Director Infrastructure Projects  
 Department of Planning and Environment  
 Major Projects Assessment  
 GPO Box 39  
 SYDNEY NSW 2001

**PROPOSED NORTHCONNEX M1 / M2 TUNNEL PROJECT - Application Number - SSI 13\_6136**

**We object to many aspects of this project**

MOTORWAY OPERATIONS COMPLEX - SOUTHERN VENTILATION FACILITY - SECTIONS
M1-M2-5000-DR-JD-0525

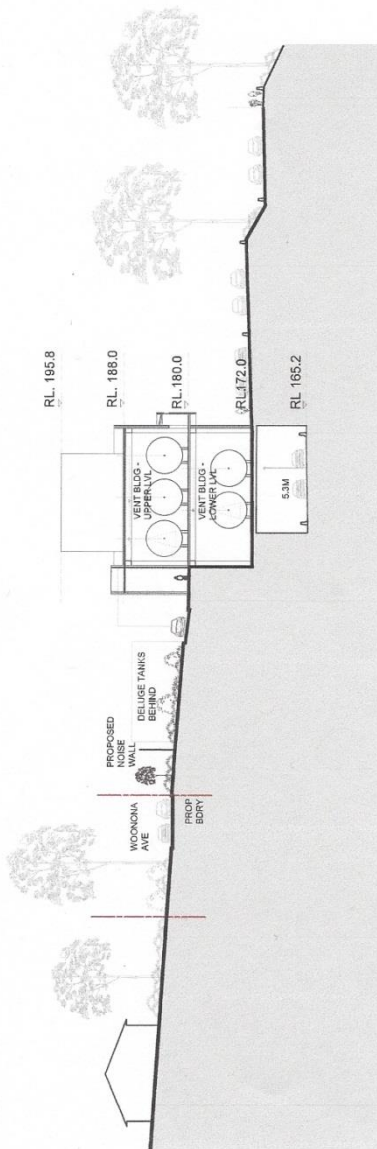
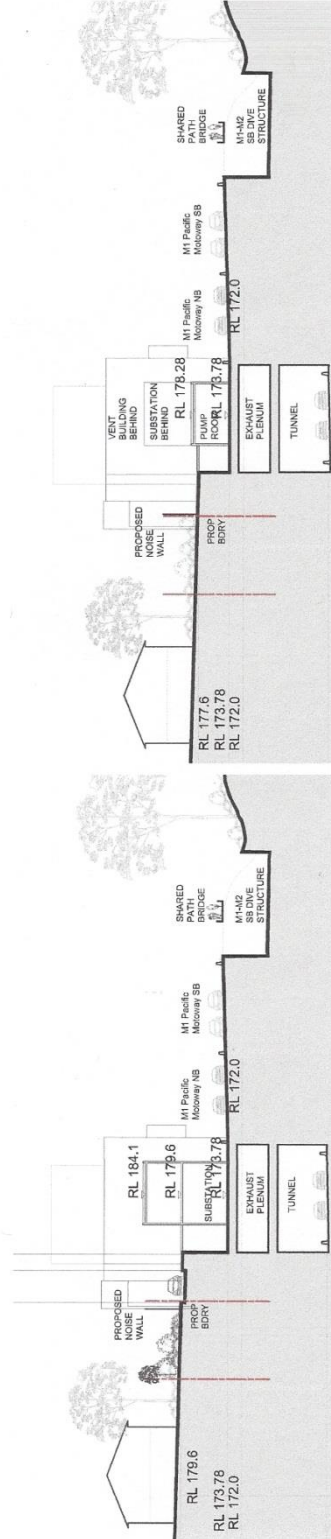
1. The Environmental Impact Statement (EIS) does not show any connection between the ventilation stack and the southbound tunnel which is 250 metres away. Will the polluted air be allowed to flow like an invisible sewer through West Pennant Hills, North Rocks, Carlingford and Beecroft?

**ACTION:** Provision of diagrams and detailed description of what ventilation is proposed for the southbound tunnel at the Southern Interchange. We would like the opportunity to lodge further submissions once that has been provided.
